**Application for a non-material amendment following a grant of planning permission.  
 Town and Country Planning Act 1990**

Minor works to the existing vehicle entrance and adjacent footpaths/cycleways to the school site, in order to provide suitable vehicle, cycle and pedestrian access to the new secondary school

R3.0032/19

Proposed Main Entrance

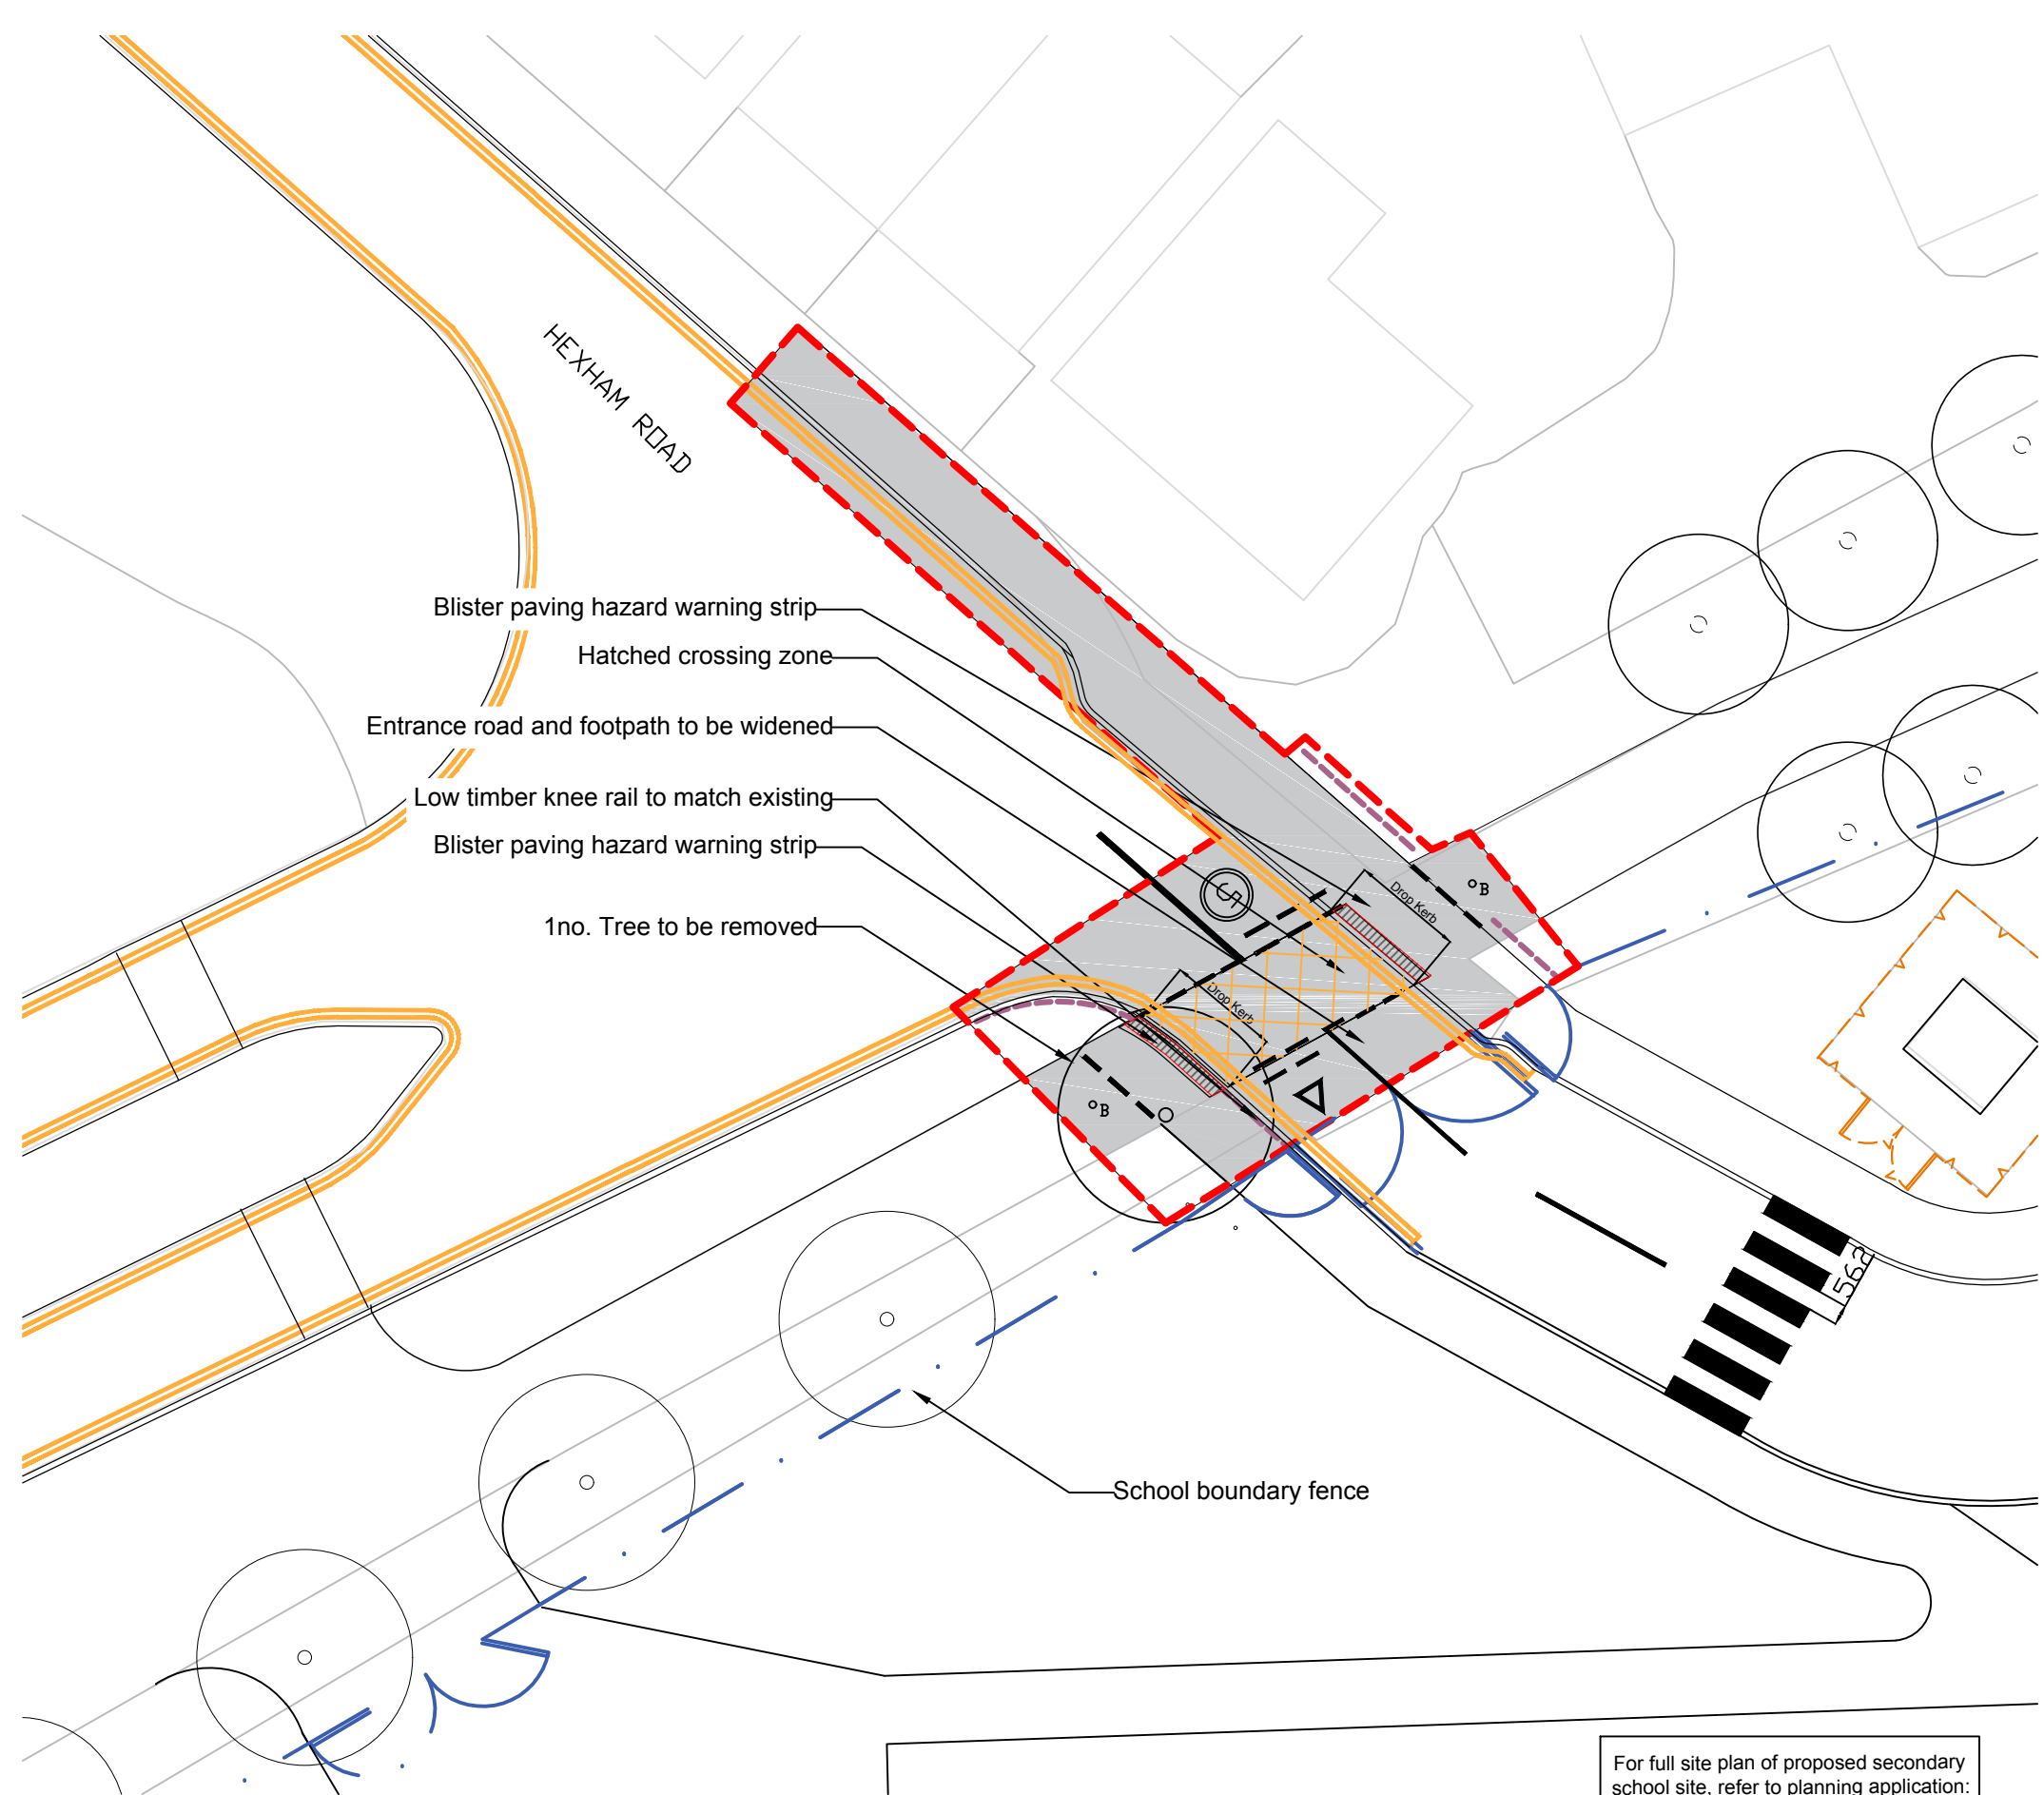
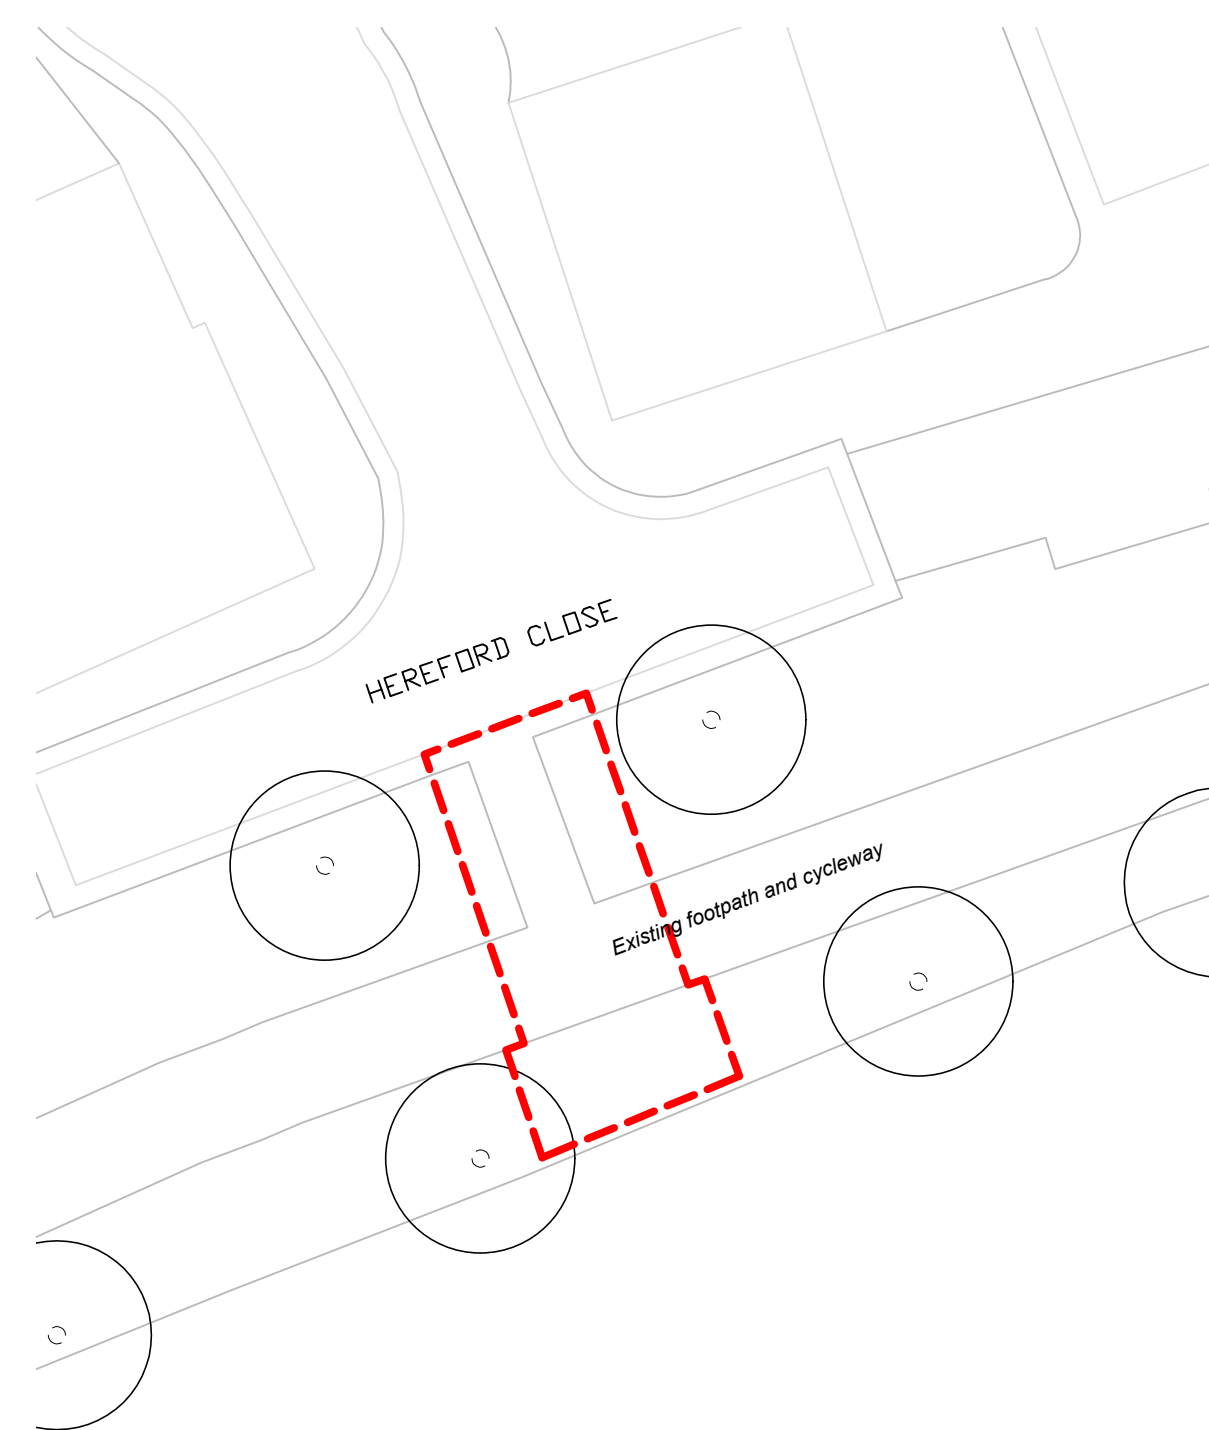
Change to Main site entrance from previous layout. Entrance is to be widened to 6m. This widening was previously shown on the east side however due to the discovery of numerous buried services it is now proposed that the widening happens on the west side of the existing entrance.

Complications caused by previously unknown services below ground
